MEMORANDUM

DATE: October 7, 2022
TO: Chris Holland, Planning Manager
FROM: Benn Burke
SUBJECT: Geddes Marina Remediation Shoreline Substantive Development Permit First Technical Comments Responses and Clarifications
CC: Steve Miller
PROJECT NUMBER: 553-2967-005
PROJECT NAME: Geddes Marina Remediation

Re.: Geddes Marina Remediation Shoreline Substantive Development Permit,
PA22-001, First technical review comments

**PARCEL MAP**

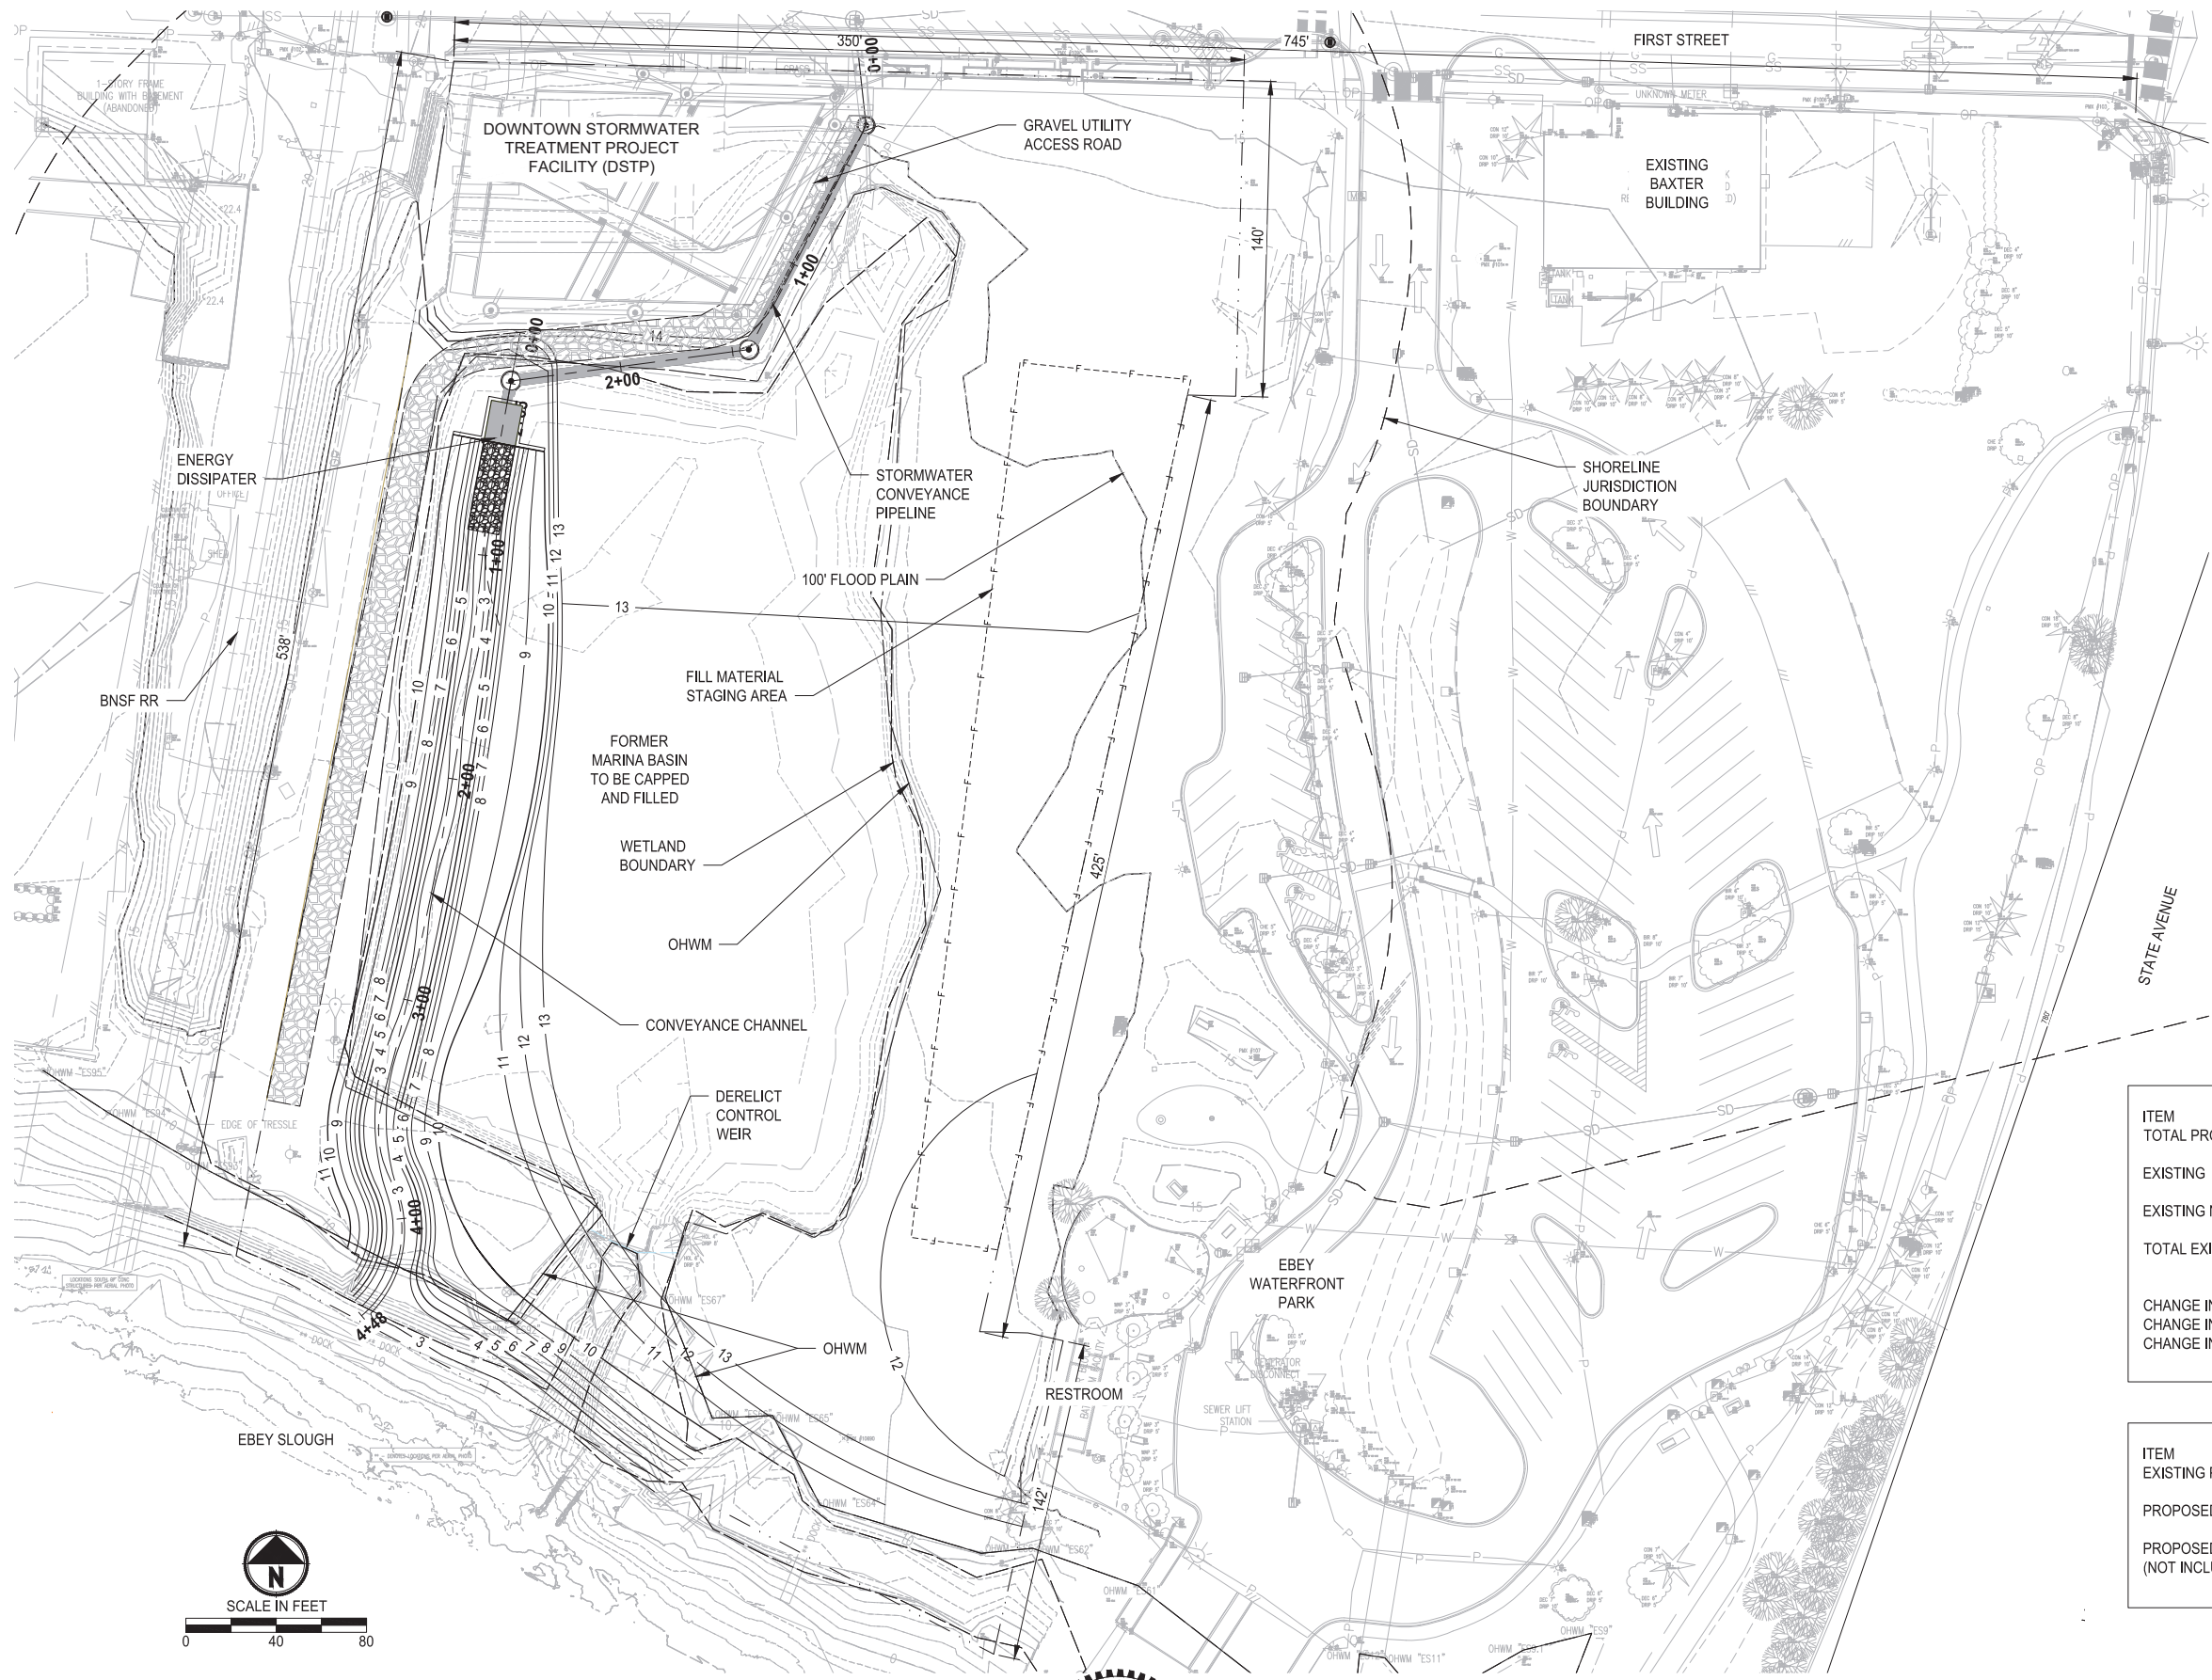
Comment 5. The Plan Set, Sheet G3 Parcel Map – please correct the parcel ID numbers for 30053300202500 and 3053300202900, and add the easements identified in Schedule B of the Title Report.

- 5) The Plan Set, Sheet G3 Parcel Map – please correct the parcel ID numbers for 30053300202500 and 3053300202900, and add the easements identified in Schedule B of the Title Report.

Response 5. The preliminary plan set submitted for the initial shoreline permit submittal has been superseded by an updated 30% plan set. We will provide an update site plan with the requested information with our next submittal.

**SITE PLAN**

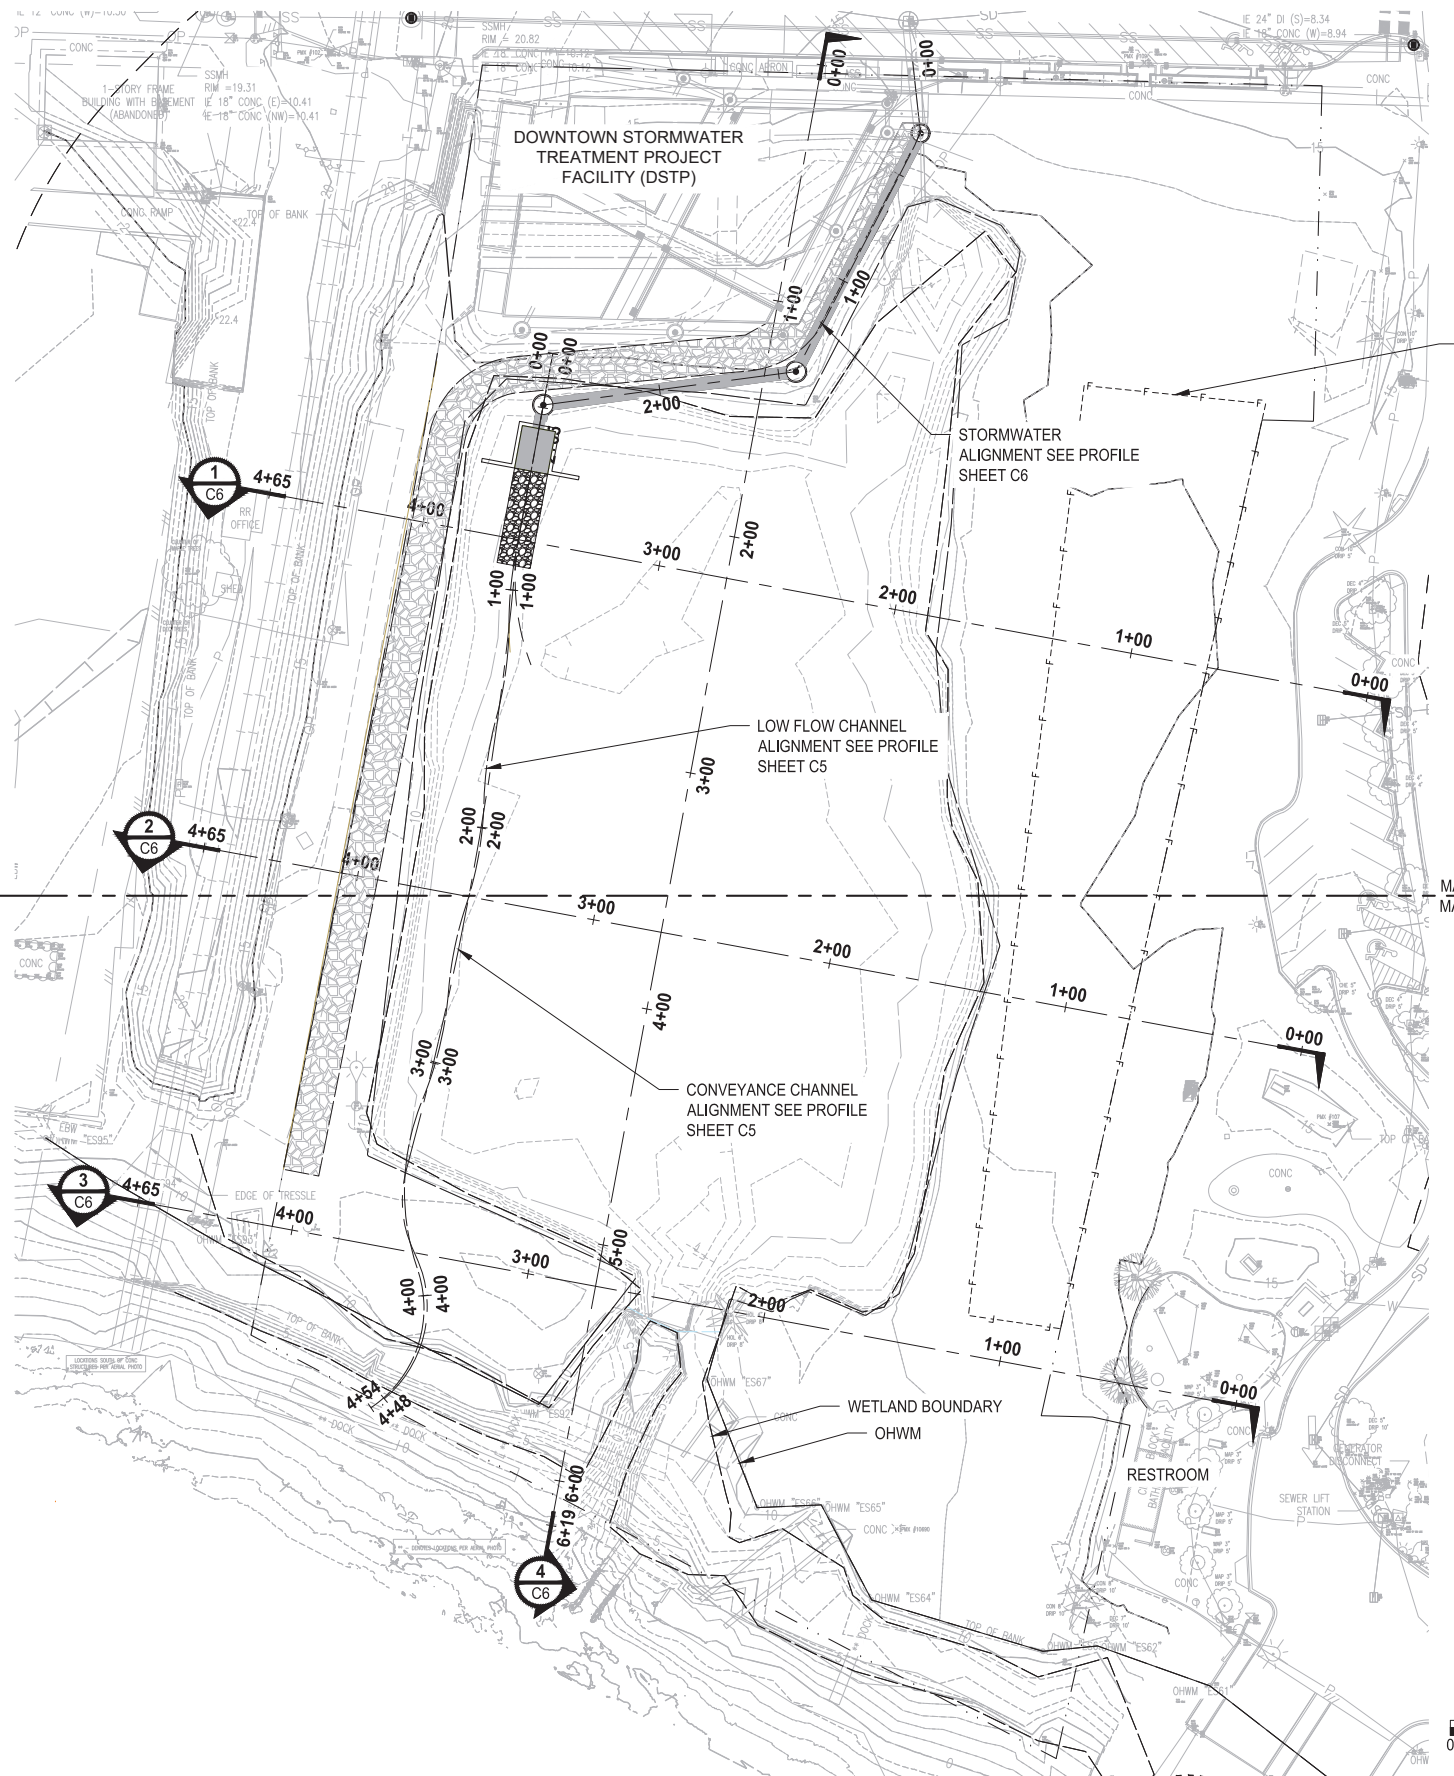
Page 6 of 17, please provide clarification regarding the response to Earth, Subsection “g”. The response states no additional impervious surface will result from the project; however, the plan sets illustrate a gravel utility access road along the length of the future storm water channel. The City of Marysville includes hard packed gravel as an impervious surface.

Page 15 of 17, Transportation, item d states no new roads, but the site plan illustrates a gravel utility access road along the west side for the future stormwater channel.

Please confirm the project will not result in an increase of impervious surfaces. All project drawings include a gravel utility access road the length of the proposed stormwater channel.

Relative to the comments on page 6 – The referenced gravel road is an existing condition. Please see 2020 air photograph cropped from the Snohomish County interactive map application (SCOPI). The project will restore the road to provide access to the channel. The project will not result in an increase in impervious surfaces.

Relative to the comments on page 15 – Please see response above related to the access road being existing. In addition, the Transportation section of the SEPA checklist is related to transportation uses. The road in question is a utility access road and is not an element of the transportation system.

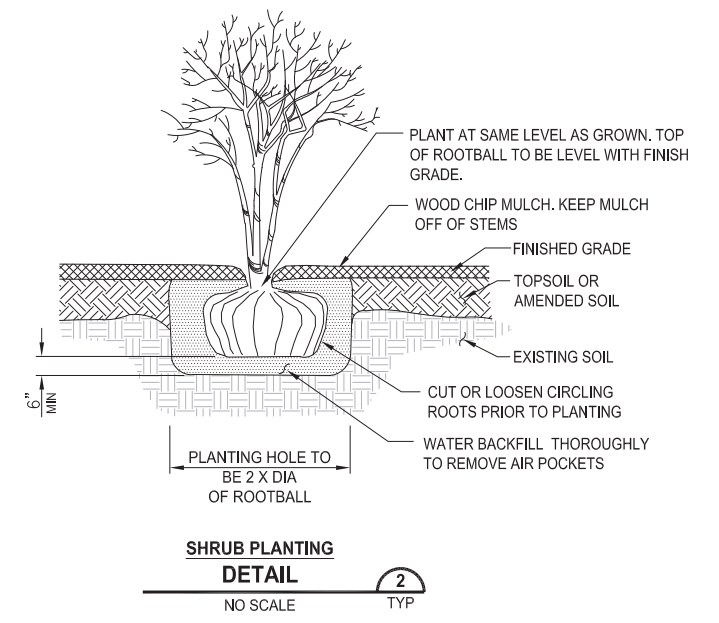
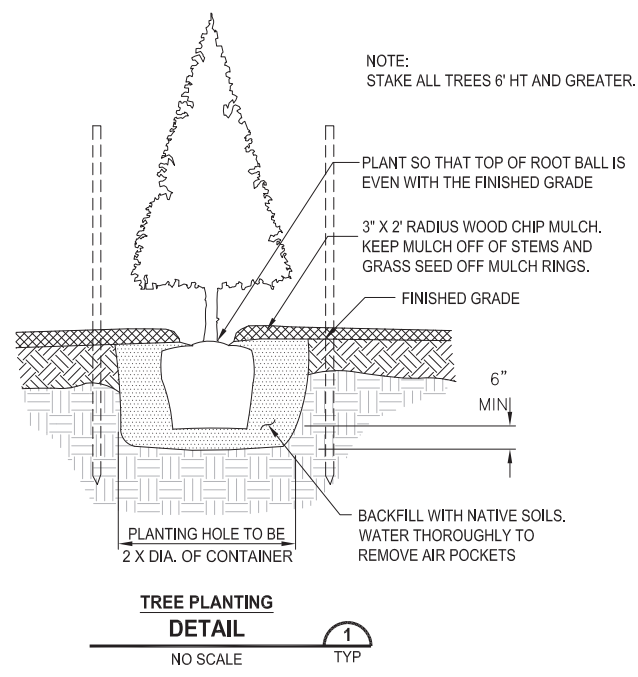
- d. Provide more details of the proposed on-site restoration for compliance with MMC 22E.010.140(1) Preliminary Plan. The critical Areas mitigation plan should include or reference Sheet LS1 Landscape Restoration Plan. There may duplication with the report; however, the preliminary mitigation plan needs to address [MMC 22E.010.140](#) (1)(a) – (1)(d).

Relative to the comments on Pages 5-1 through 5-3. During our preapplication meeting with City Community Development staff we discussed the project approach and what information relative to the mitigation plan would be required. However, given the period of time between the shoreline submittal and the current date, Parametrix has completed a detailed Mitigation Use Plan, which was submitted in support of the Corps of Engineers Section 404 permit in April. This will be included as an appendix to the revised Critical Areas Study and includes the requested information.
